Project Name: SEVEN BAR RANCH

City of Albuquerque
Planning Department
Inter-Office Memorandum

TO: Jack Cloud, DRB Chair
FROM: Randall Falkner, Planner
SUBJECT: Project # 1003658

On July 17, 2008, the Environmental Planning Commission approved Project # 1003658 08EPC-40066/40067/40068, a site development plan for subdivision, a site development plan for building permit, and a request to amend site development plan for building permit for Tract D-4-G, Seven Bar Ranch, zoned SU-1 IP, located on NM 528 between Ellison Drive and Corrales Road, containing approximately 9.3 acres.

SCALE: 1/4" = 1'-0"

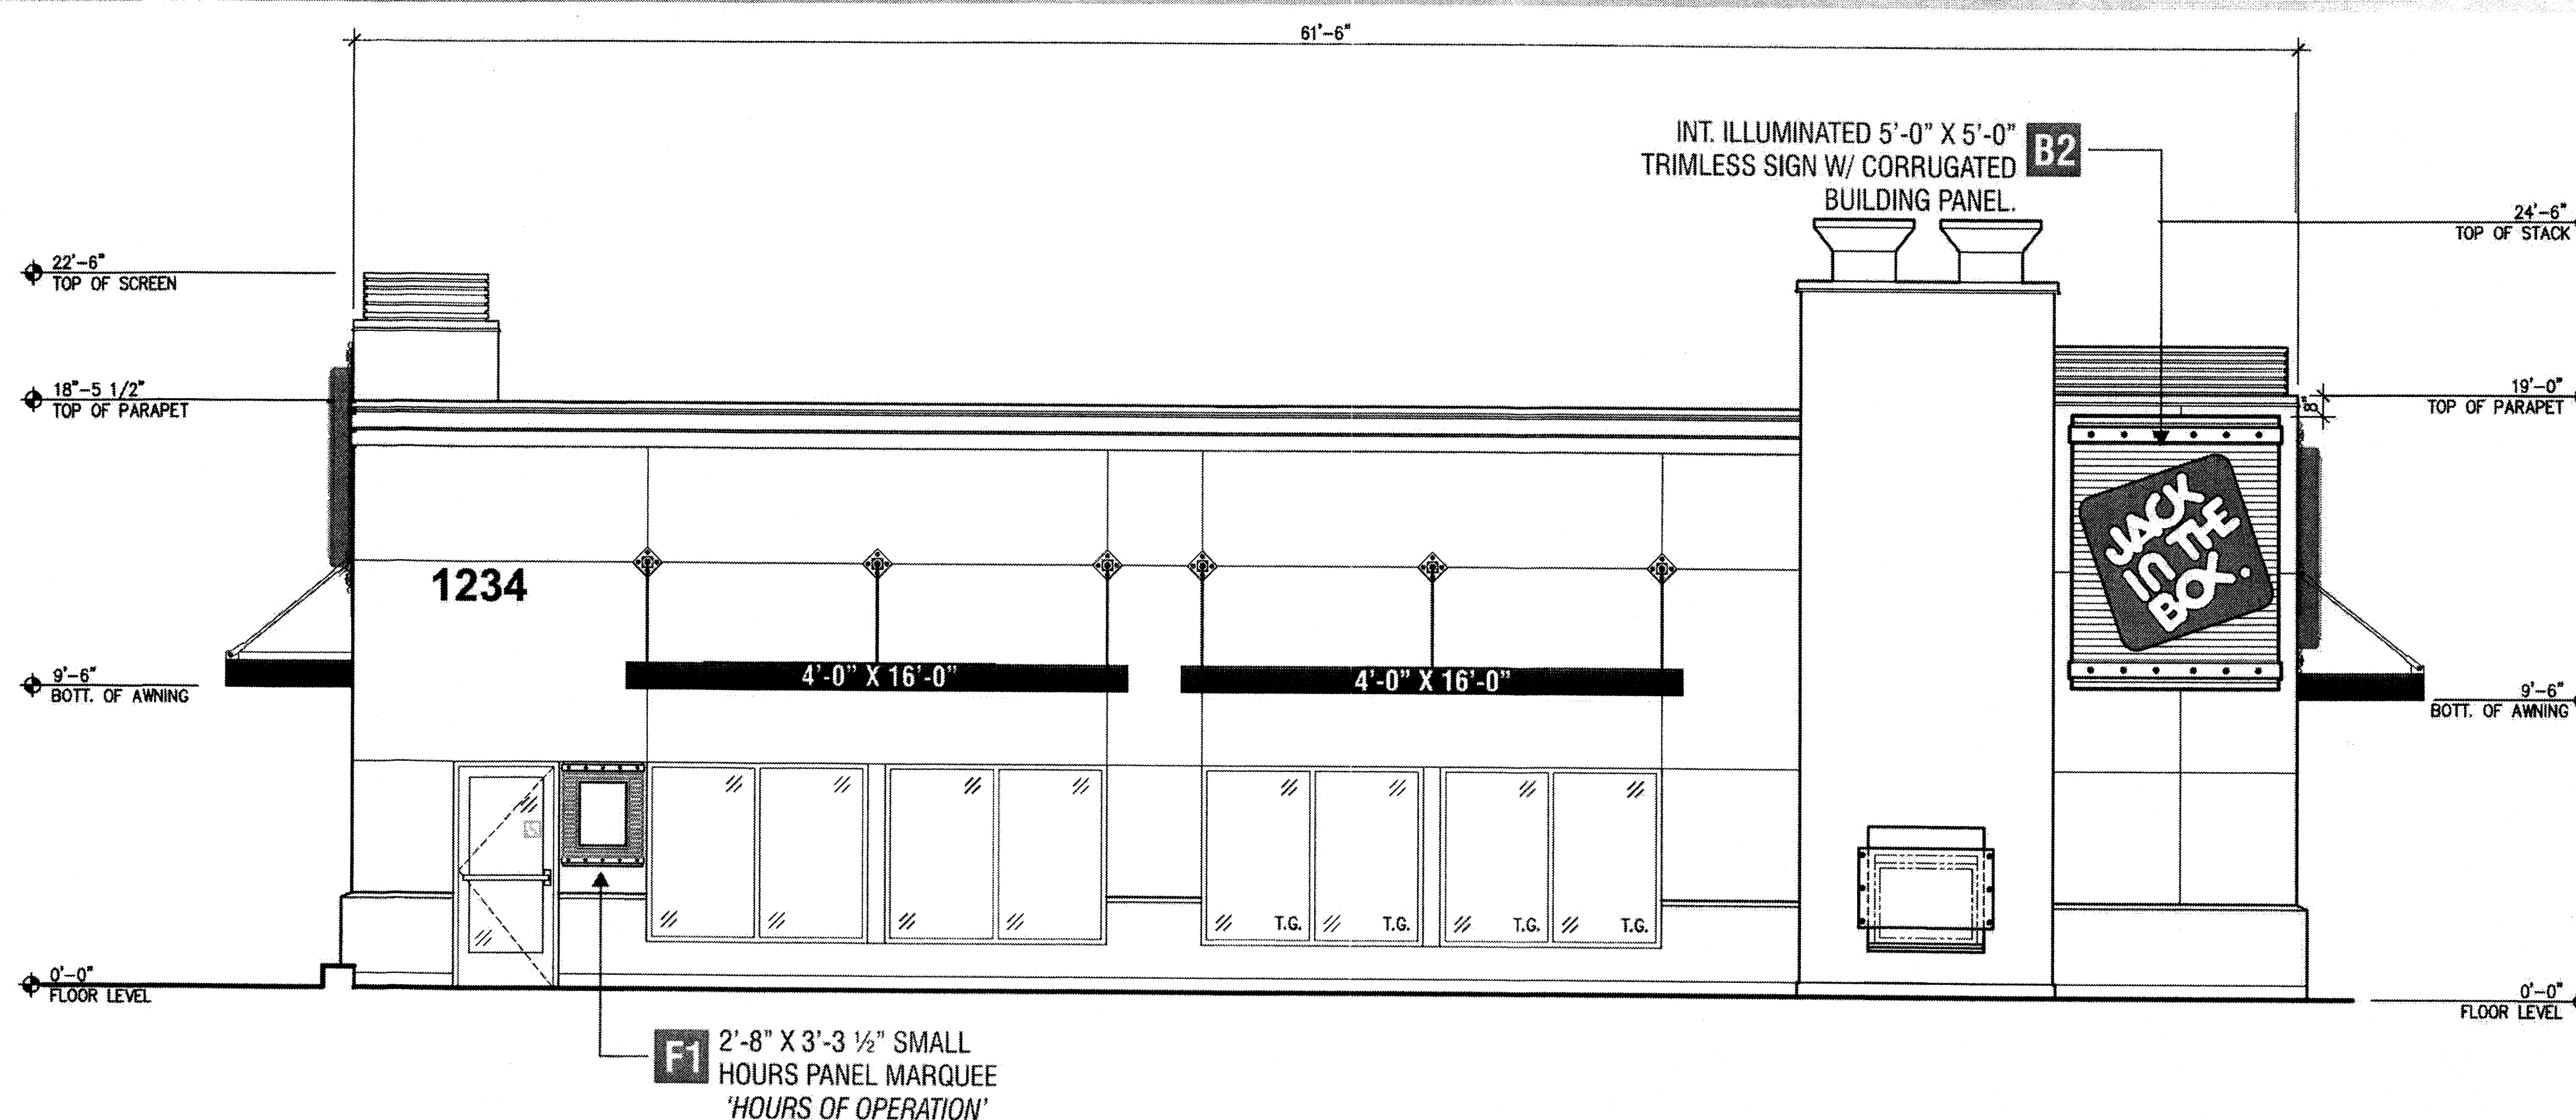
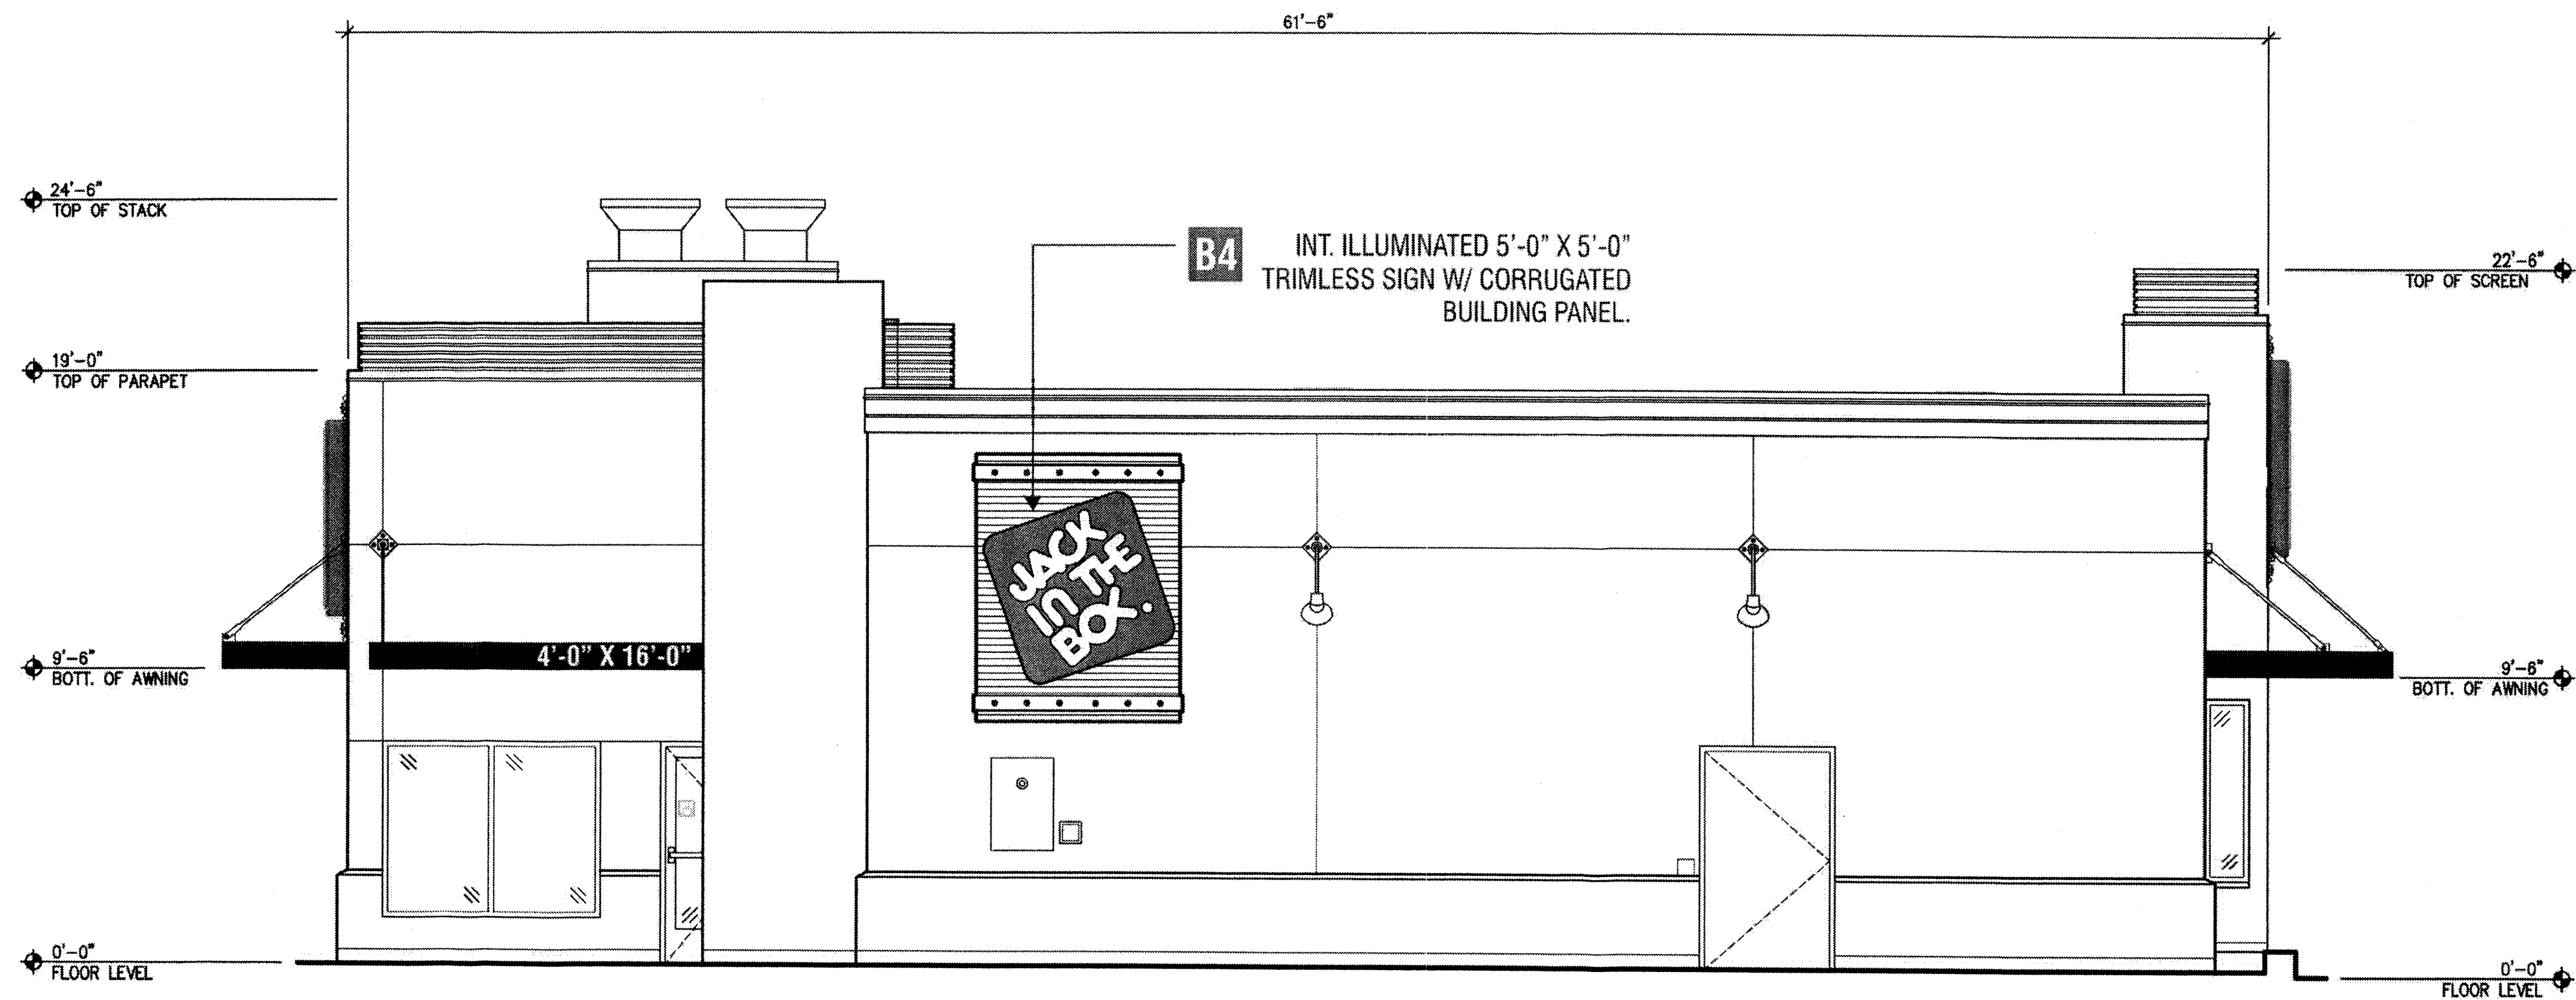
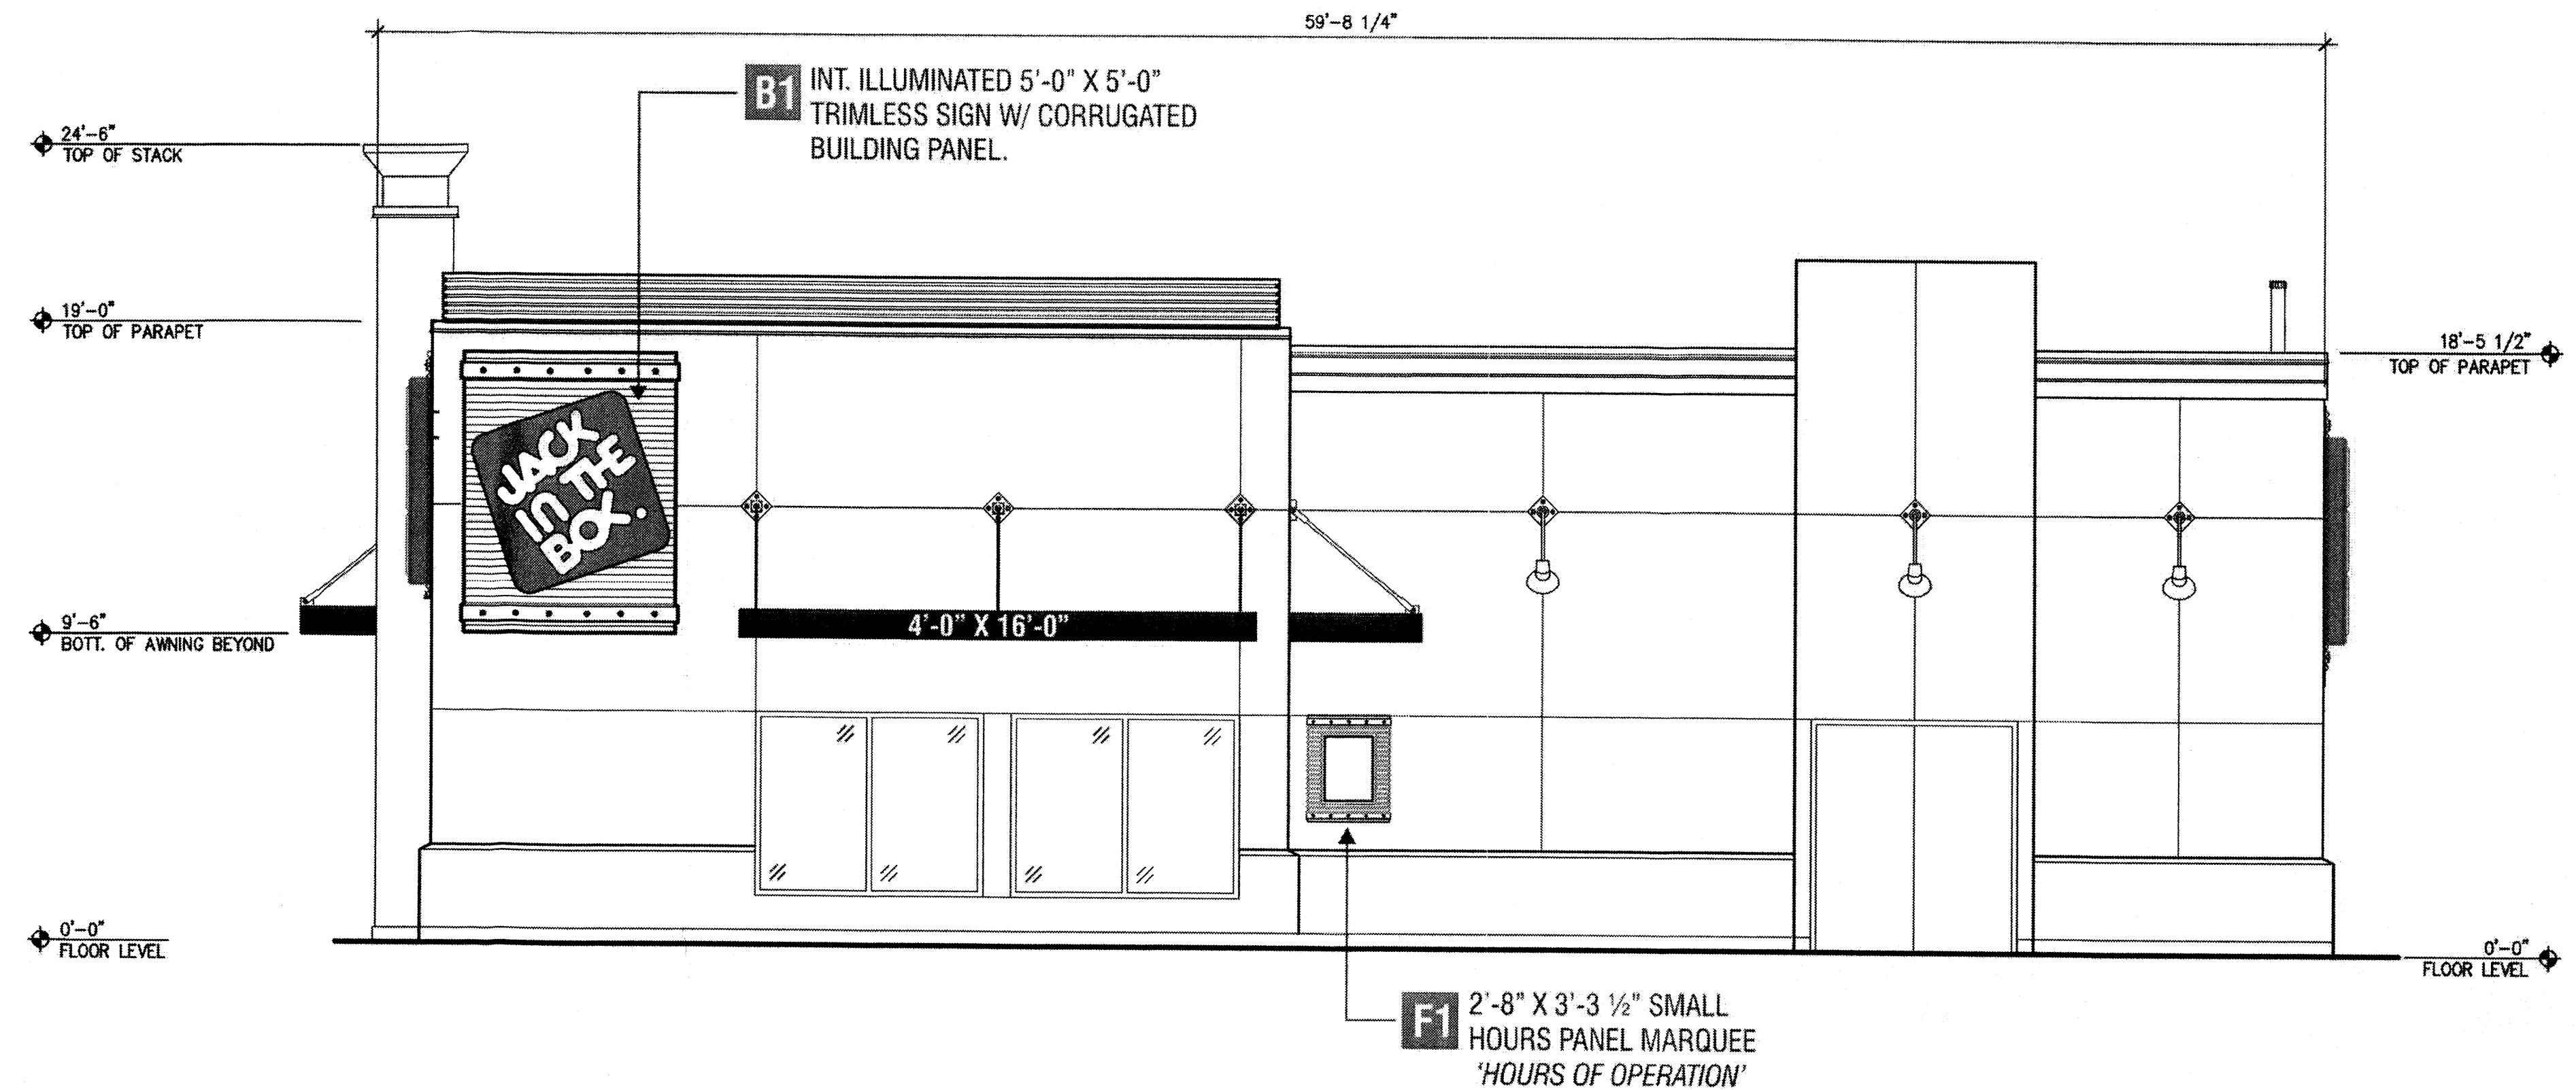
Sheets 3 and 4 in the final submittal are the same Sheets with the same elevations (south and west). One of the Sheets should contain both the north and east elevations.
